CROWN STREET DEVELOPMENT APPLICATION
SUMMARY OF SUBMISSIONS

LEGEND

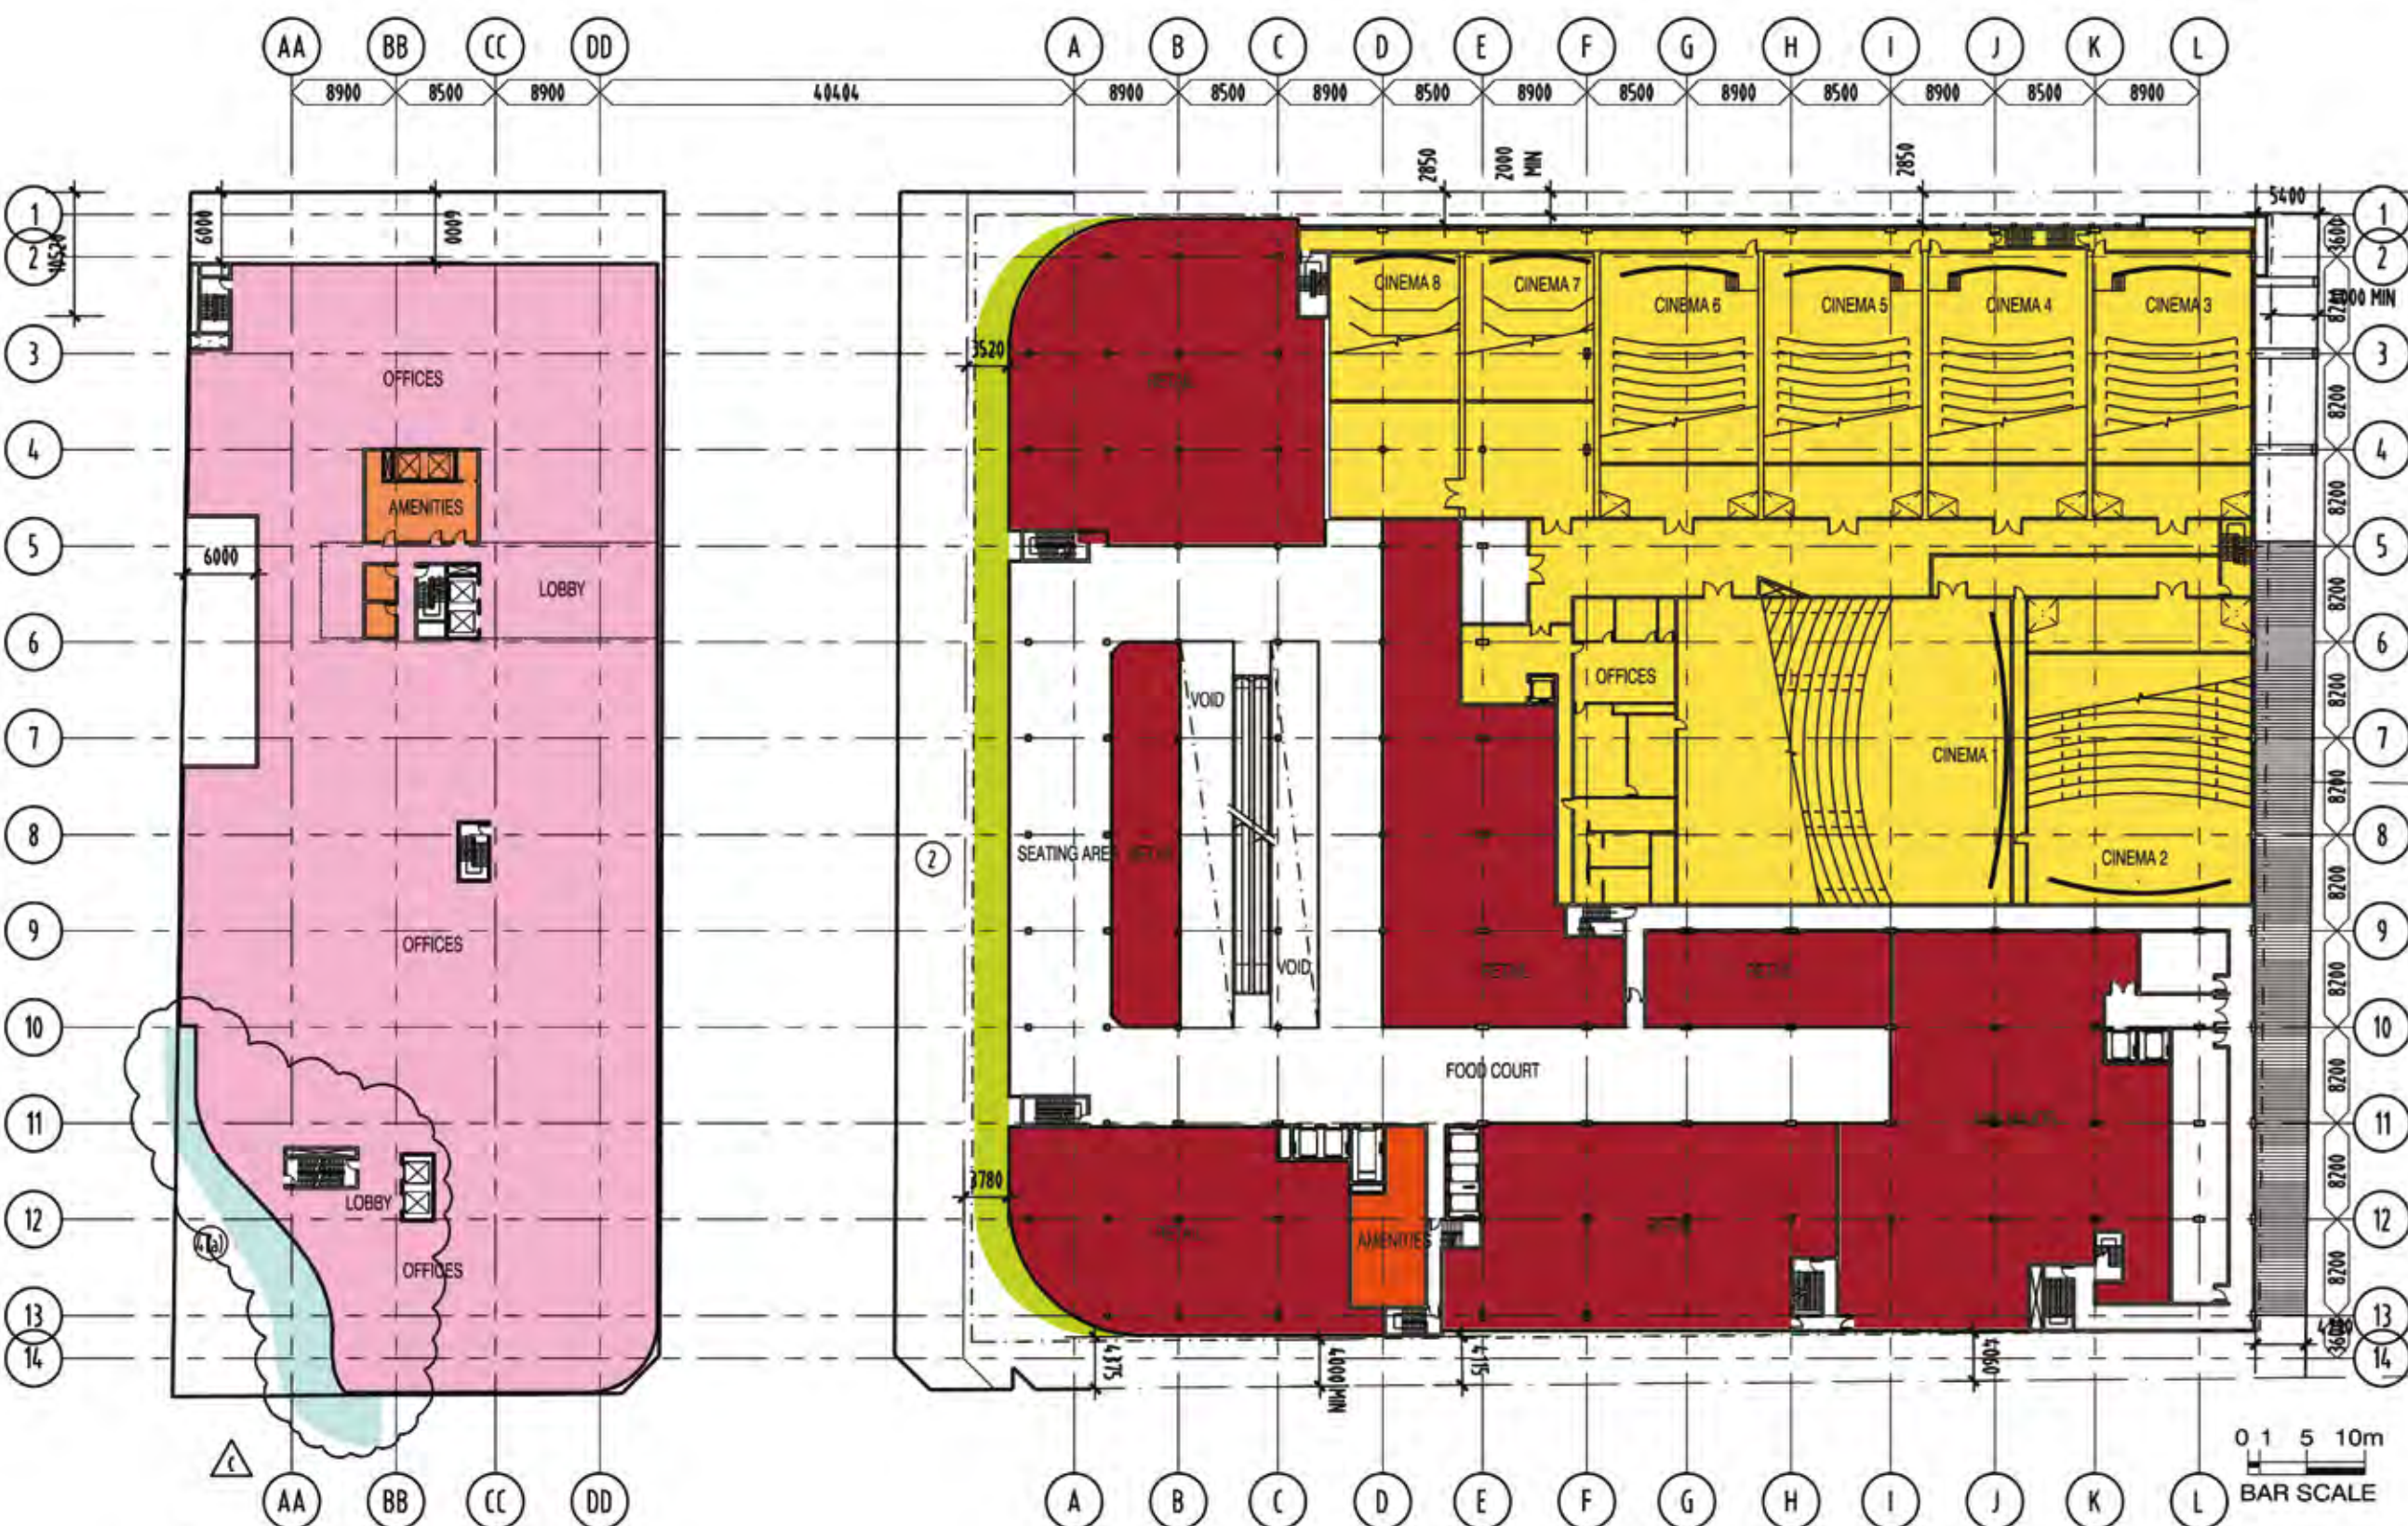
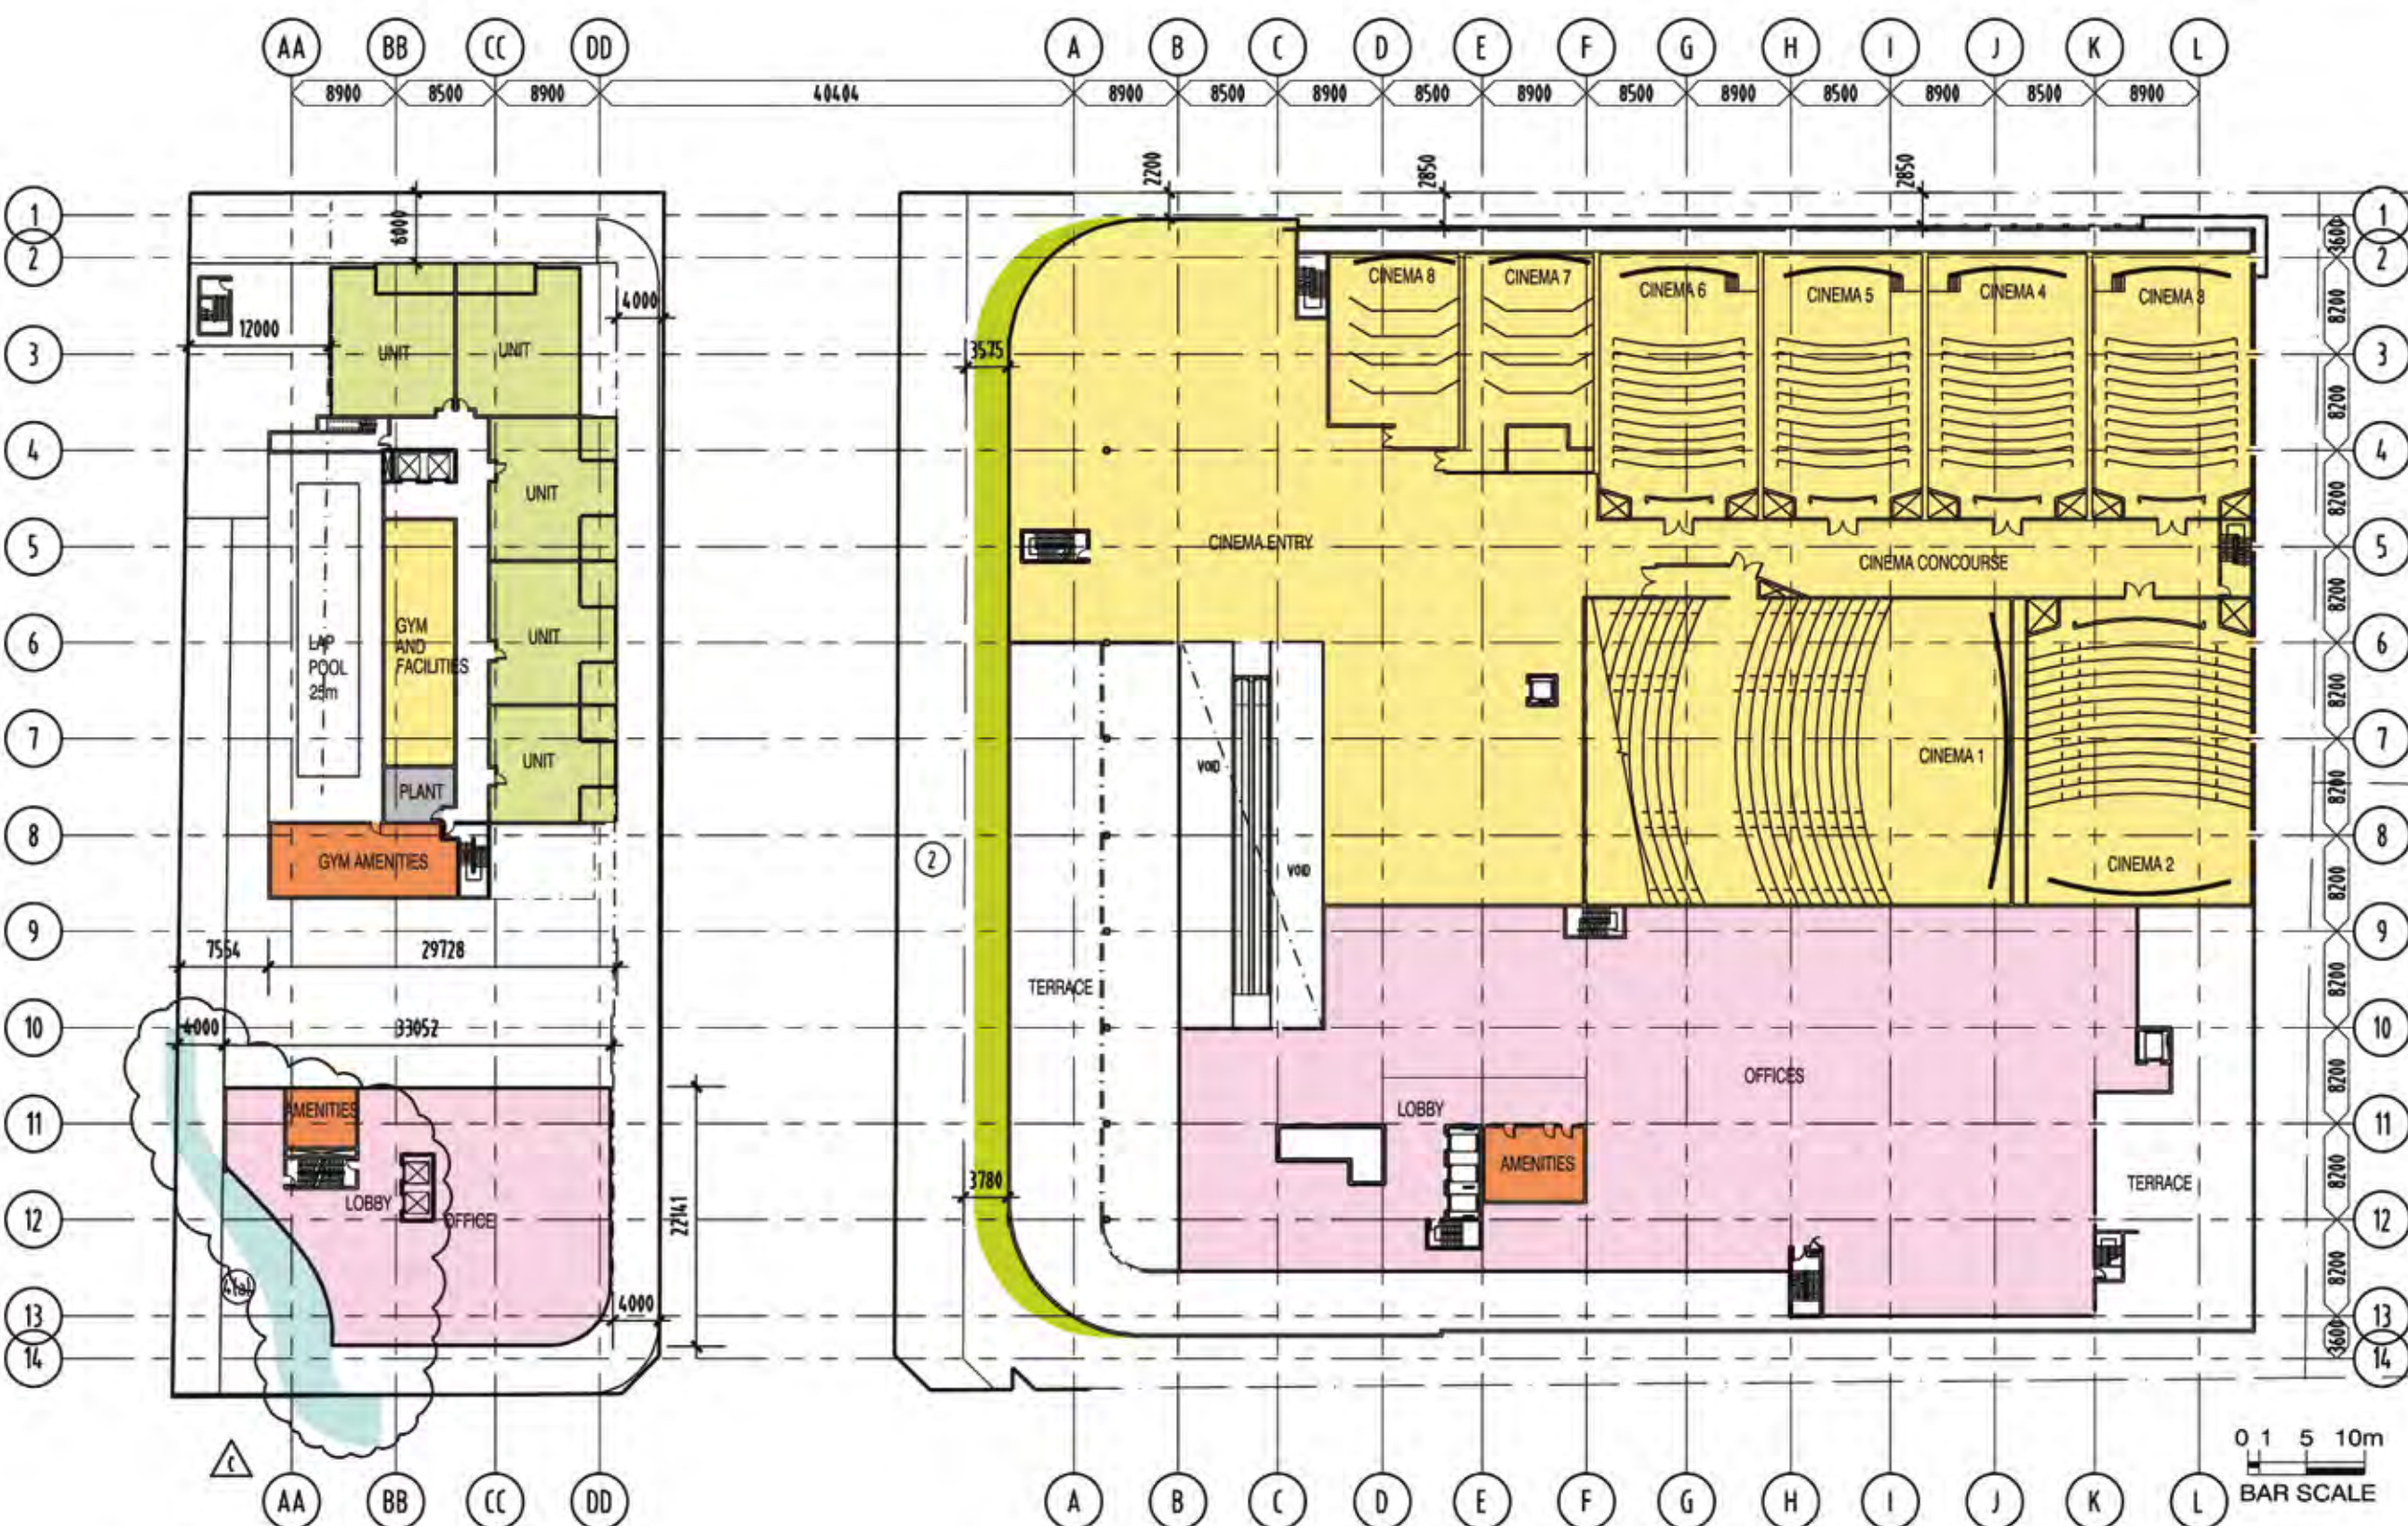
Ref No.	Submitter	Issue	Comment	Recommended Action
		6.2 Proposal is inconsistent with road widening reservations. • Proposal for Dwyer's site encroaches on road reserve along Corrimal Street – amended plans required to include setback. • Oxford site shall be redesigned to allow for road widening in accordance with WCC Infrastructure Division's Dwg No. 4268, 01/08.	Amendments have been made to address the proposed road widening of Corrimal Street. See also address in Urbis covering letter. As also addressed in the Urbis letter, it is considered onerous for Council to require further road widening of Town Hall Place.
